Recommendation Report for Planning Permission

REF NO: EP/93/18/PL

LOCATION: 9 Nursery Close
East Preston
BN16 1QD

PROPOSAL: Variation of condition 2 imposed under EP/145/17/HH to change drawing number of plan drawing to reflect rebuilding of section of wall rather than retention.

| DRAWING No.<br><b>17-085-7</b>                                 | REV<br><b>d</b>                                                                                                  |

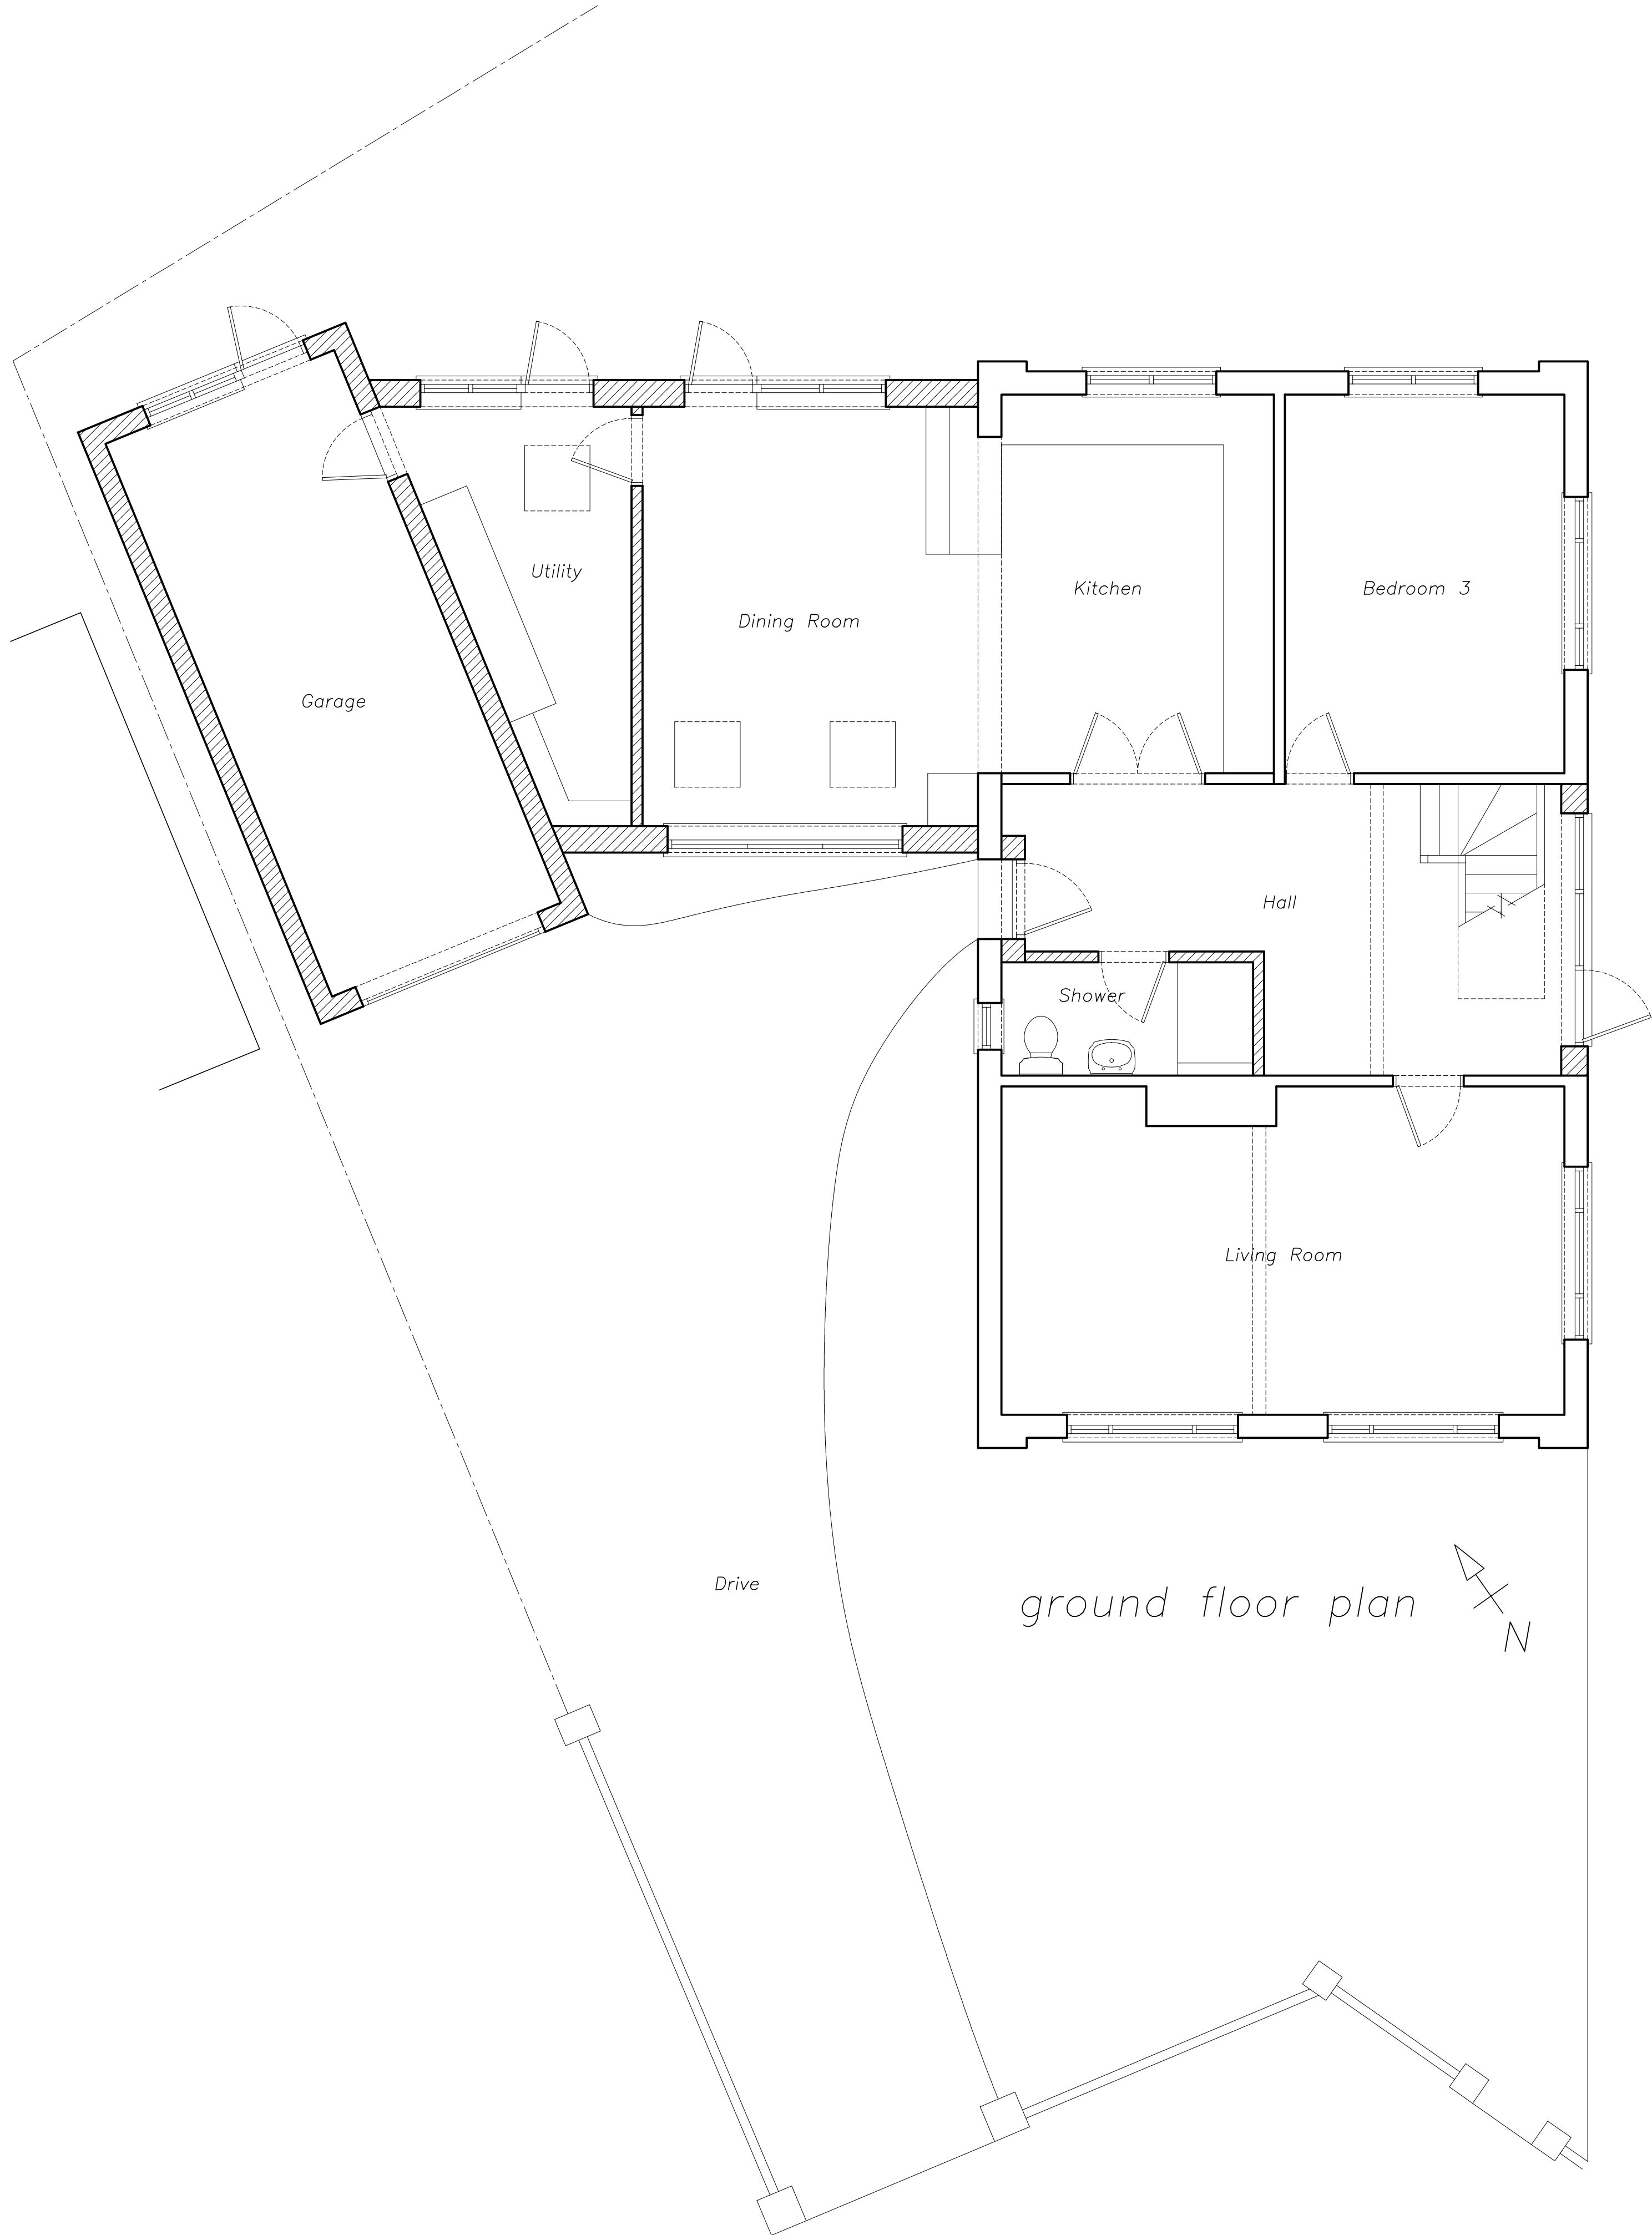
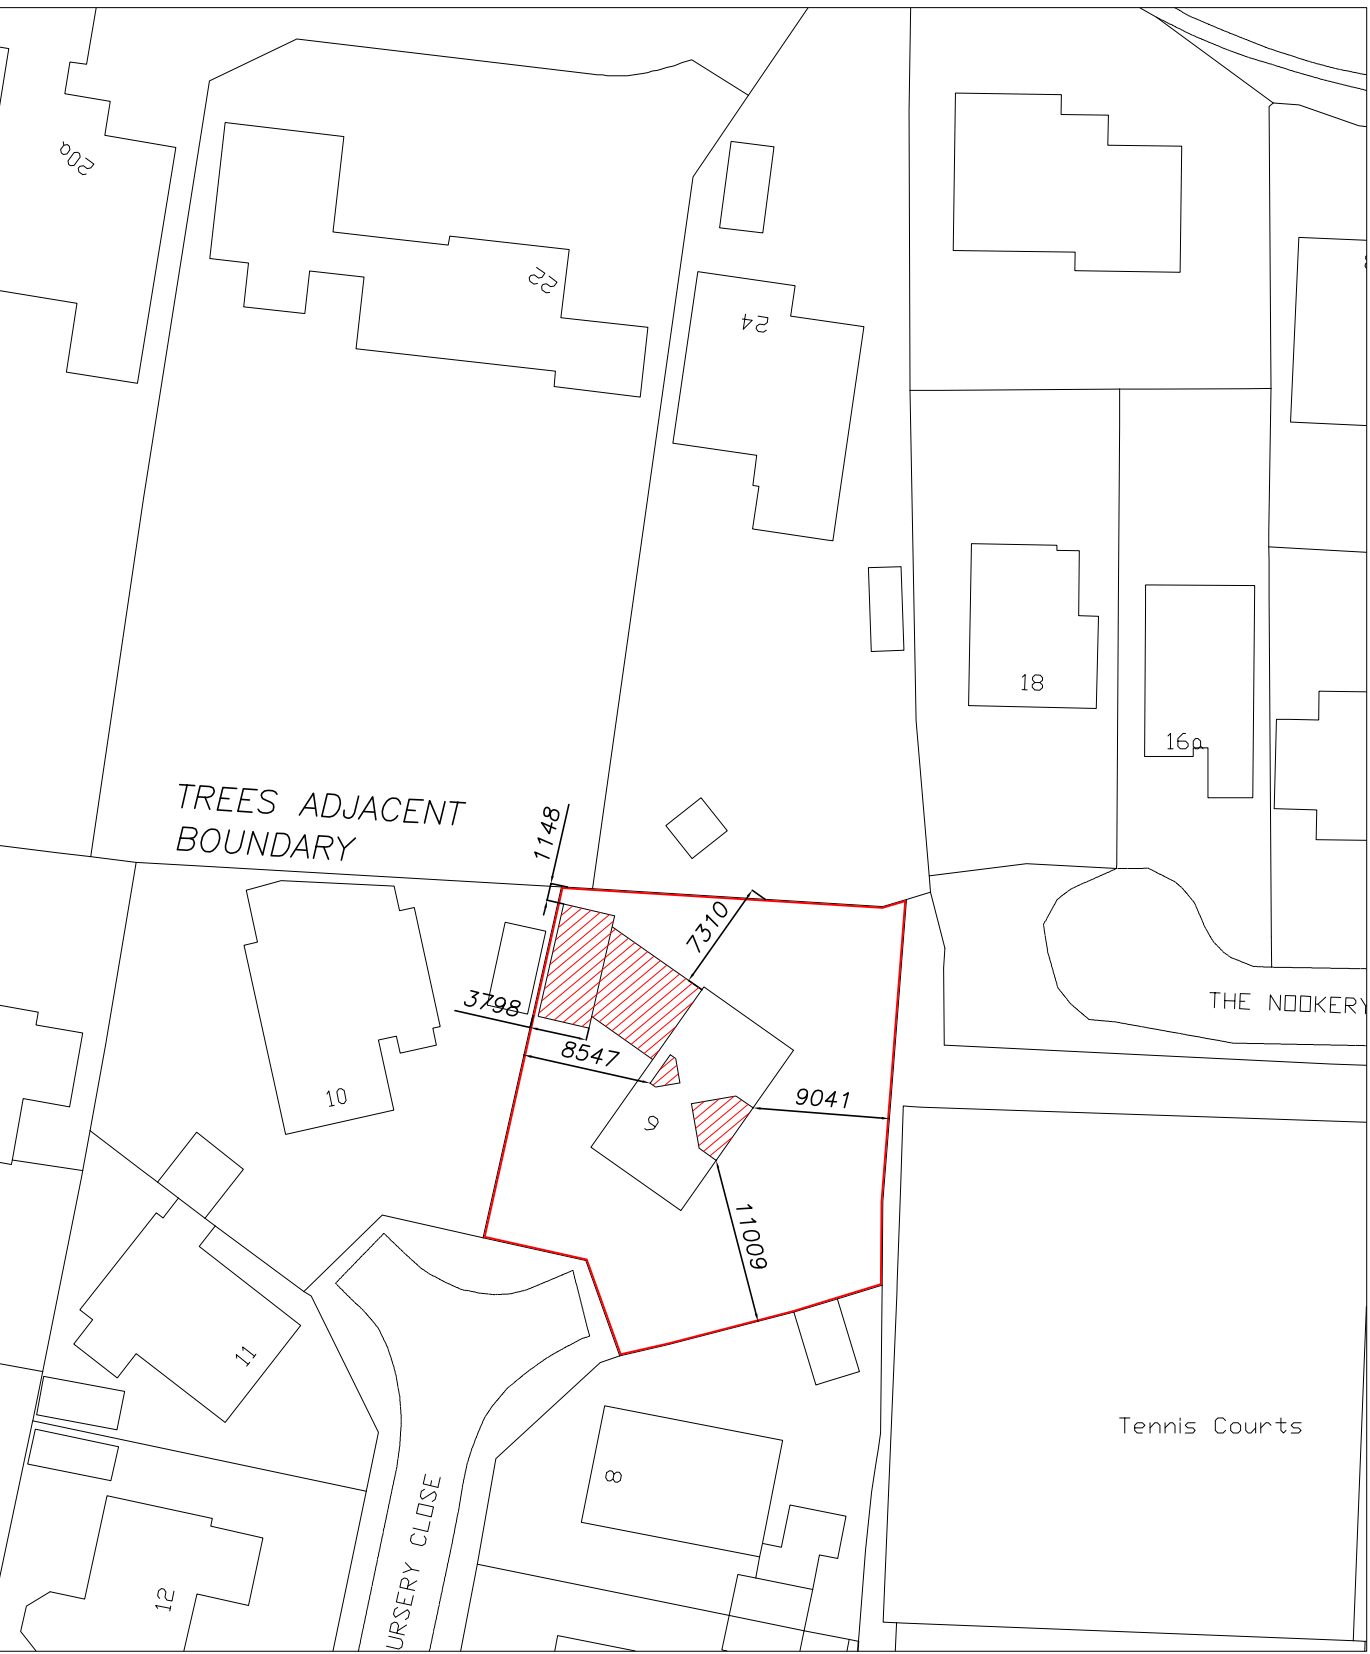
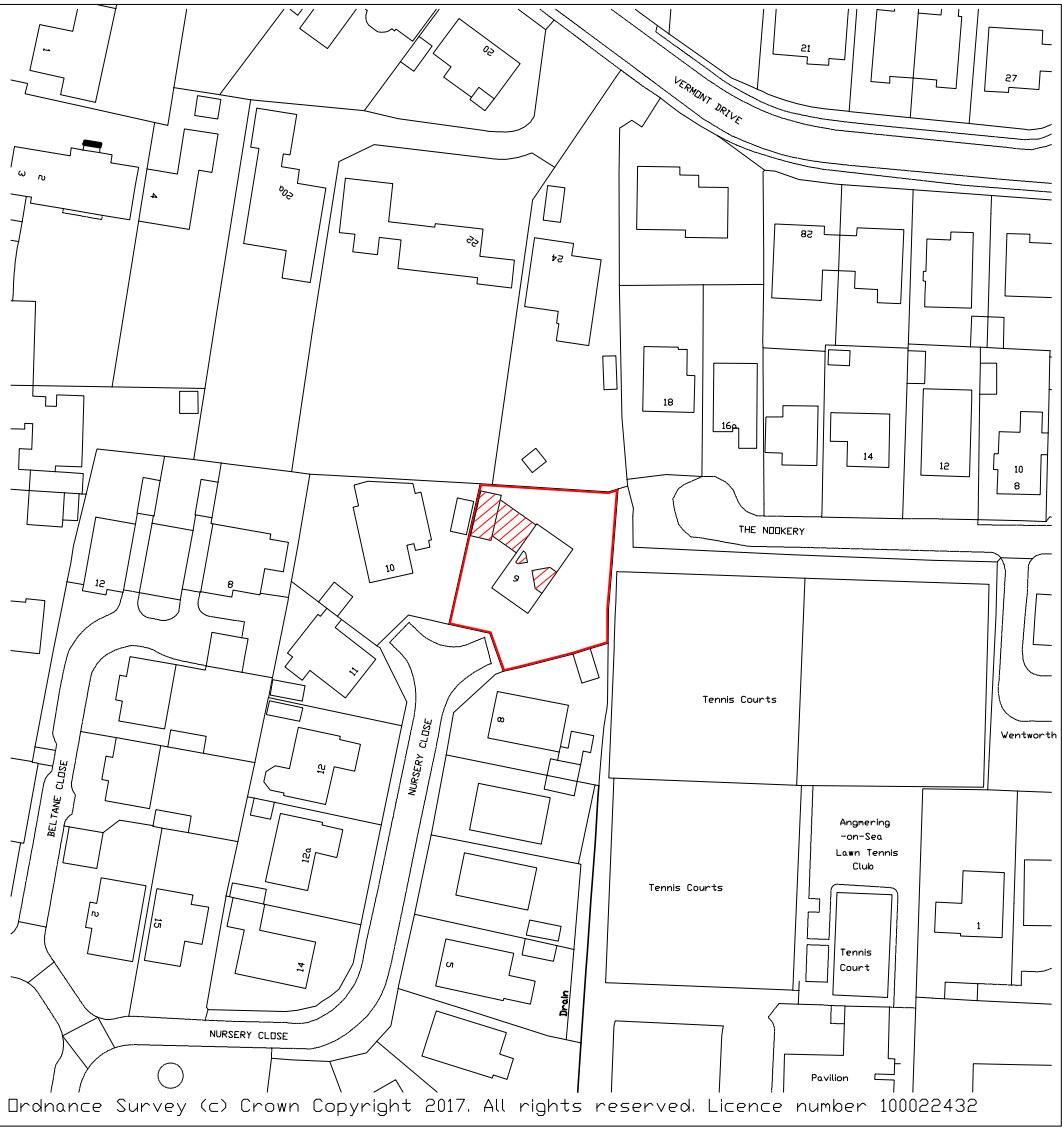
Officers note that this permission seeks a variation of condition number 2 of the previously granted application ref: EP/145/17/HH as the part of the side wall of the garage that was to be retained is unsuitable for retention. There was also a discrepancy highlighted regarding the sitting of the rebuilt garage which did not match the submitted plans.

In this case, the applicant has only submitted 1 plan showing the proposed ground floor plan in order to highlight that the wall, as aforementioned, is no longer to be retained but instead rebuilt. After a site visit it was revealed that this aspect of the proposal was in the correct position and in accordance with the submitted plan. All other aspects of previously granted application ref: EP/145/17/HH are to remain the same as granted.

This application aims to keep the proposal the same as that previously granted under application ref: EP/145/17/HH, except rebuild part of the side wall of the garage, facing number 10, rather than seek to retain a section of the existing wall. Having regard to this and the above assessment, it is considered that the proposal, incorporating the new section of wall, would not have an unacceptable detrimental impact on the occupiers of neighbouring properties and the wider area. Therefore it is considered that the proposal should be granted subject to the following conditions.

17-085-7 Rev D as submitted with this application and:

- 8 INFORMATIVE: It should be noted that this application makes amendments to Condition number 2 (Plans Condition) of previously granted application ref: EP/145/17/HH. The submitted plan ref: 17-085-7 Rev D replaces Plan number 17-085-7 Rev C of previously granted application ref: EP/145/17/HH.
